DOC19/588259-24

**Re SSD 6619 MOD 1**

I refer to the notification the Environment Protection Authority on 27 November 2019 from the Major Protects Portal about the modification application to State Significant Development 6619 proposing the inclusion of a battery formation plant at the existing Enirgi Power Storage Recycling Pty Ltd's (Enirgi) used lead acid battery recycling facility located at Bomen.

## **Attachment A**

Figure 5-2 CALMET derived 2013 annual wind rose for the proposal site

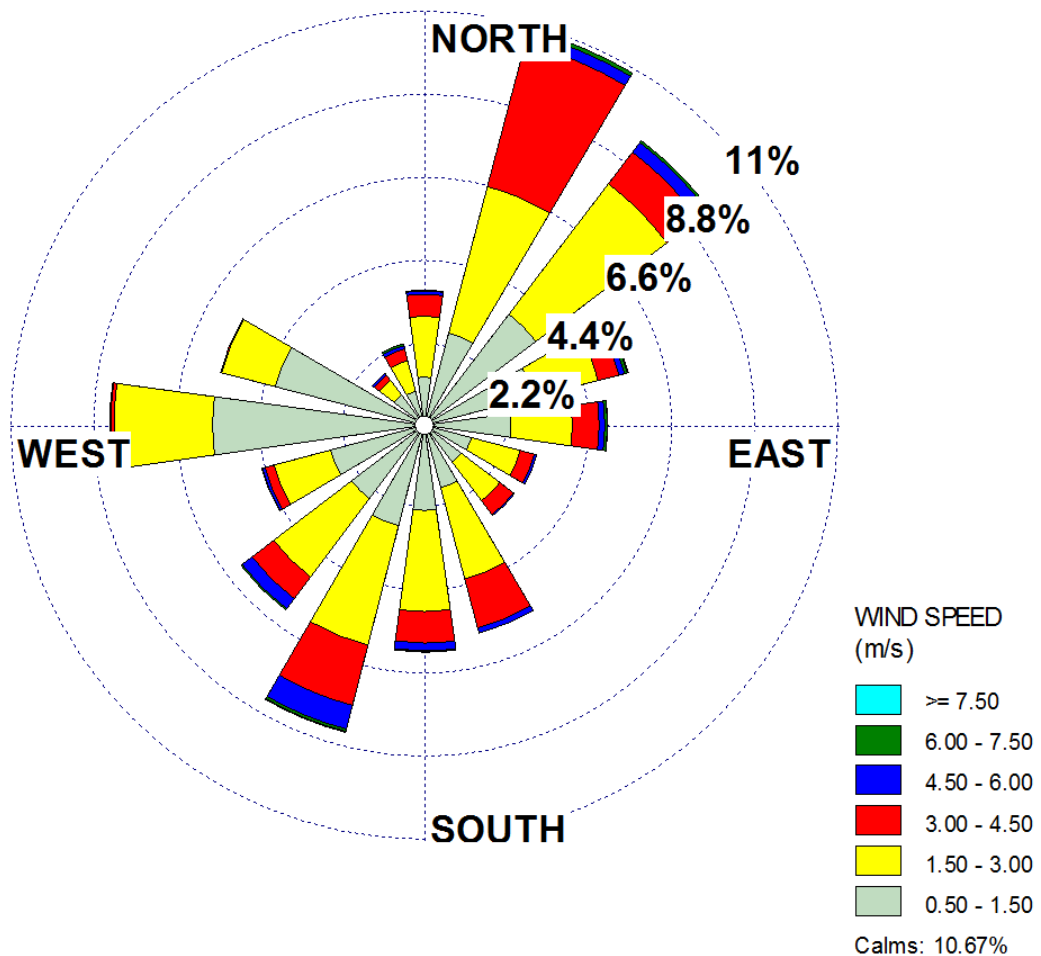
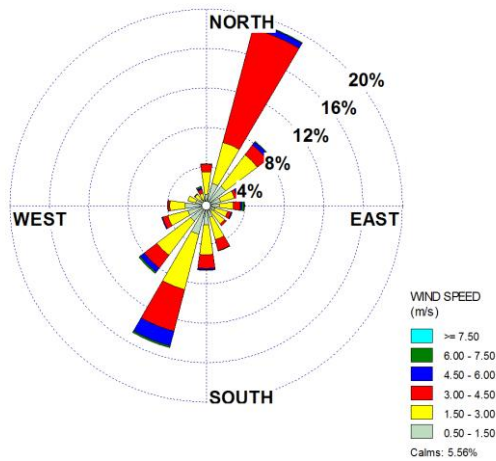
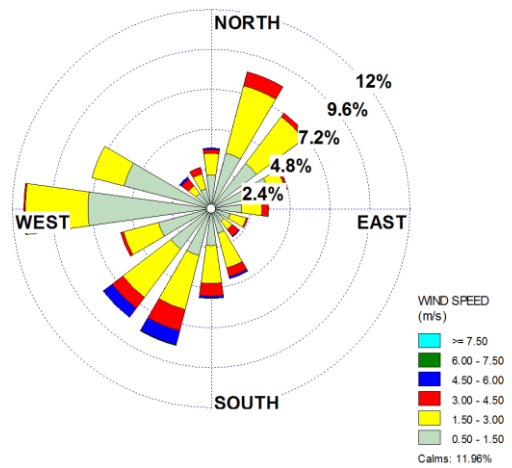
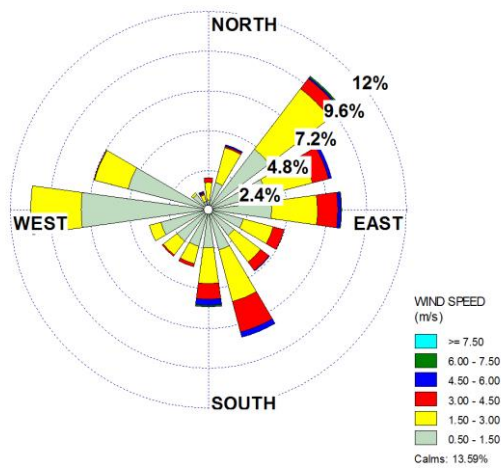
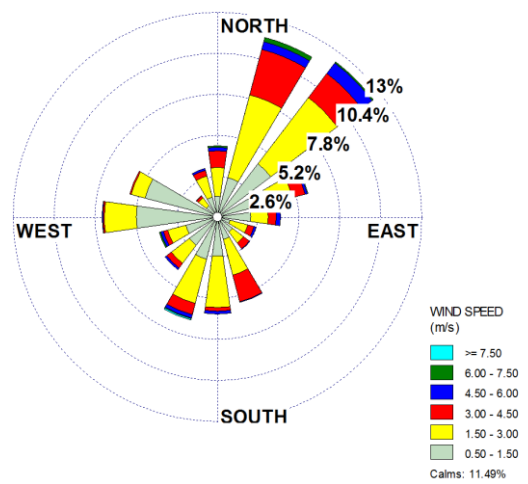
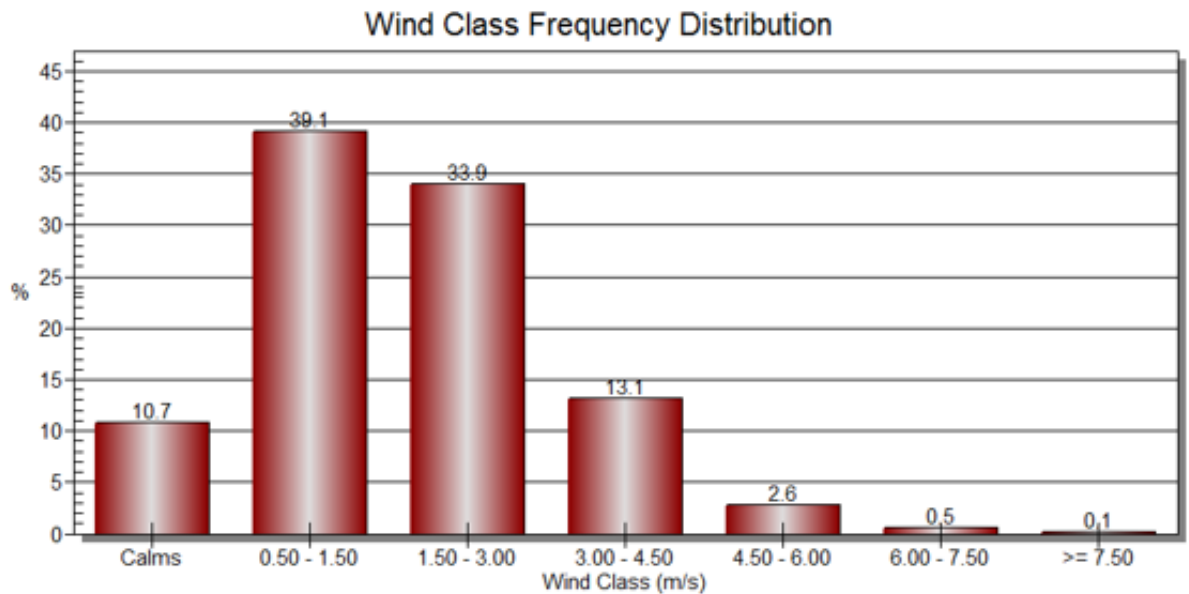
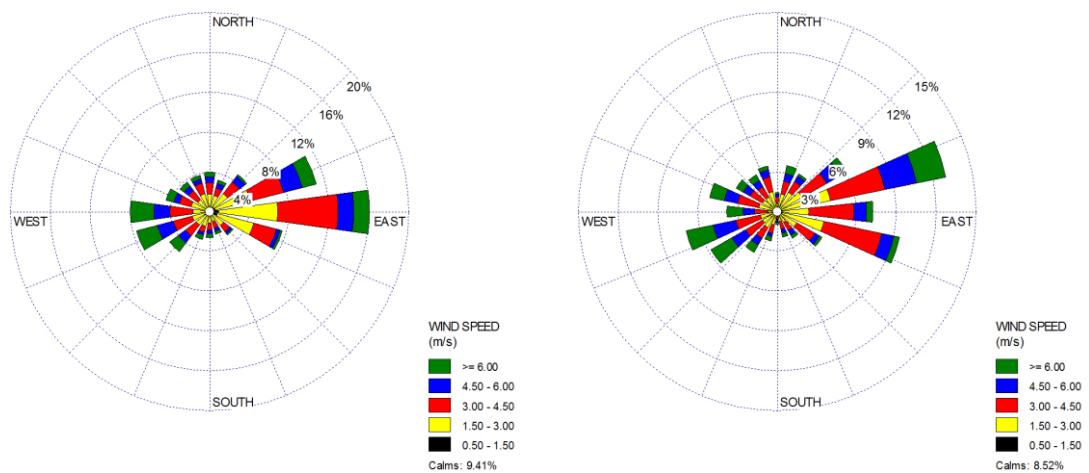
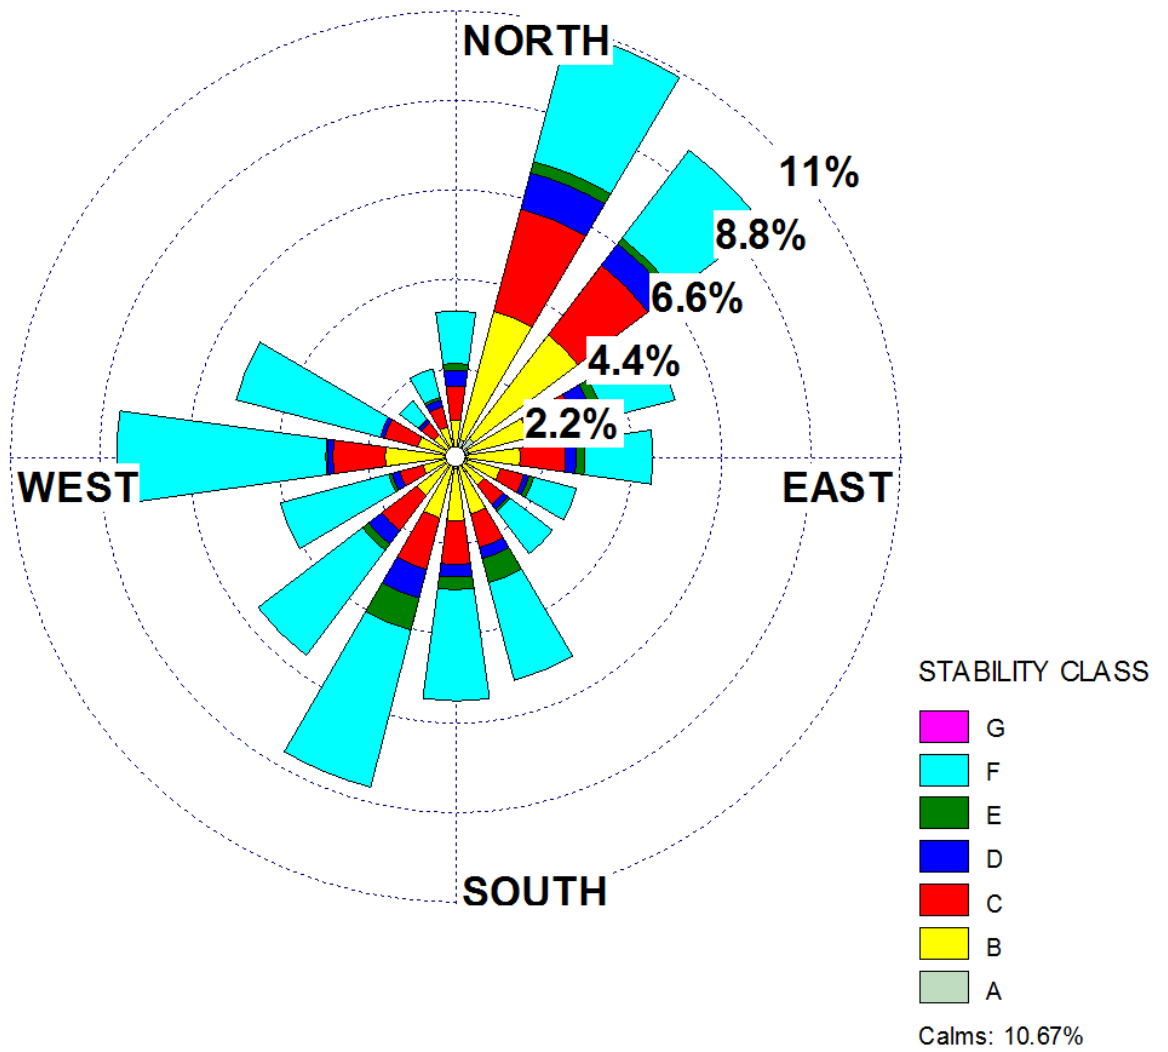
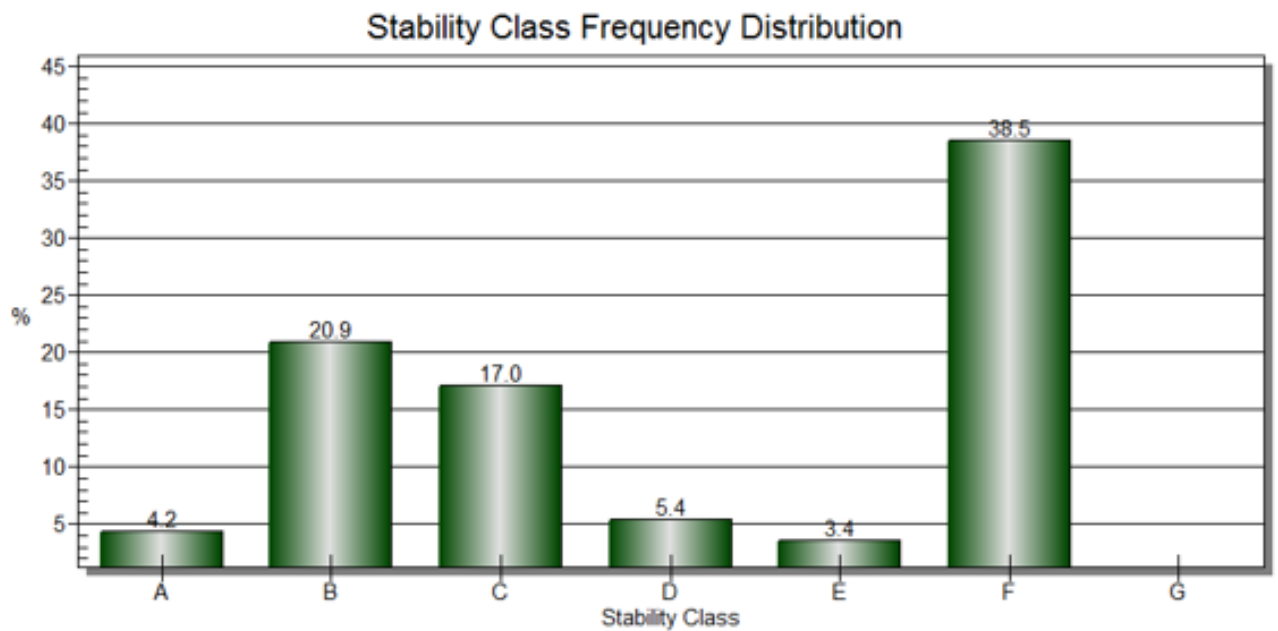
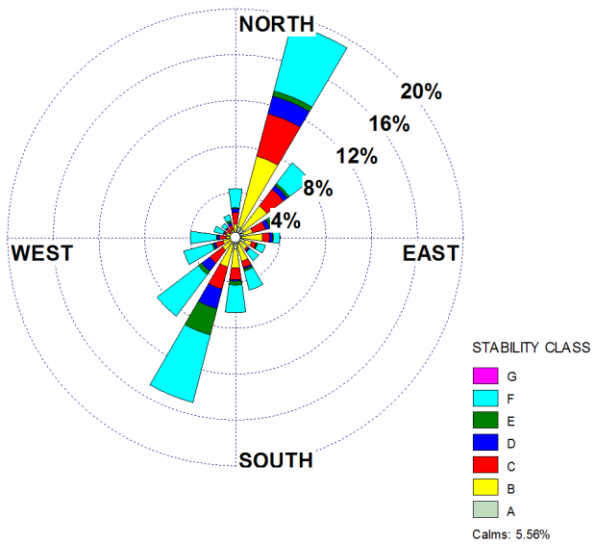
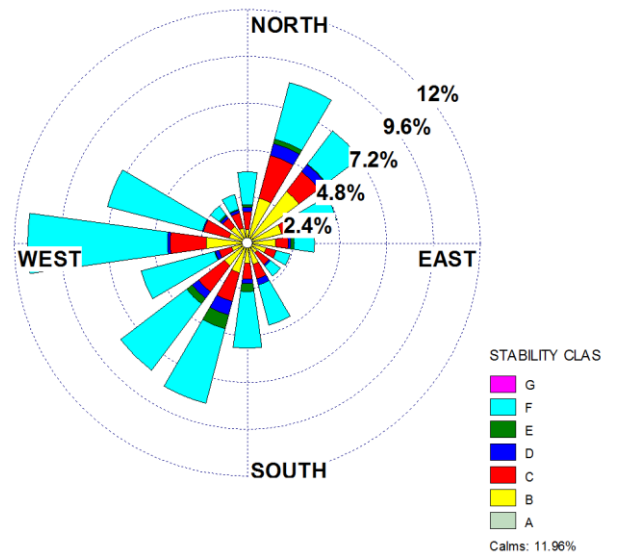
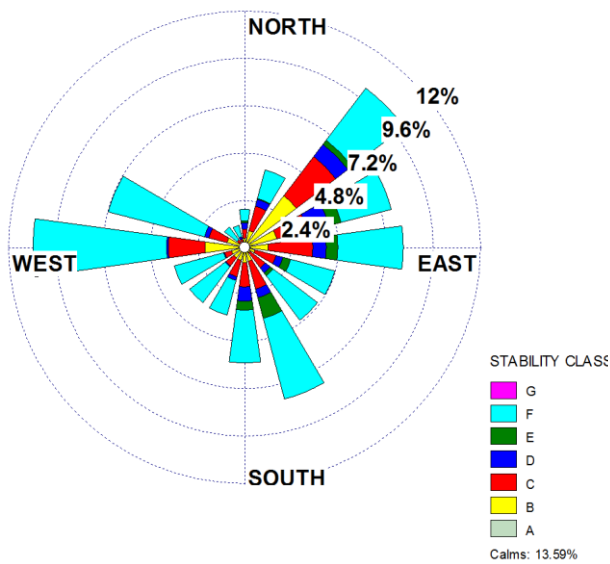
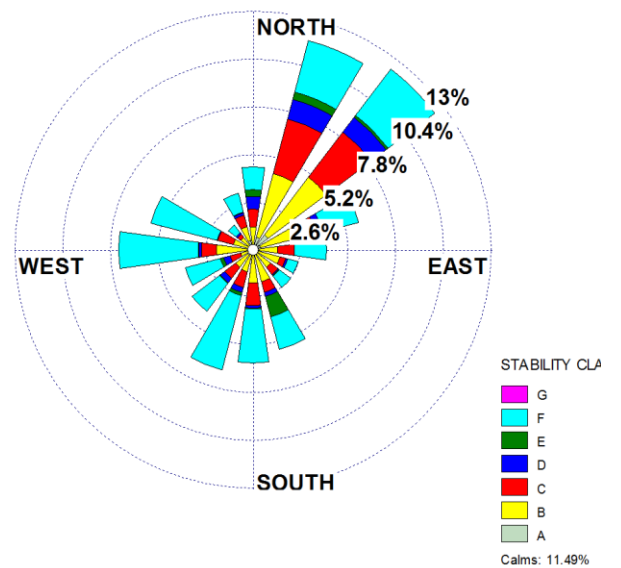
The AQIA states an onsite weather station was used in the assessment but only provides meteorological data generated by CALMET and comparison of annual CALMET data to Bureau of Meteorology data for Wagga Wagga North.

We recommend the proponent provide as additional information, the meteorological data from the onsite weather station, including where possible, as a minimum: annual and seasonal wind speed, wind direction, temperature and stability class.
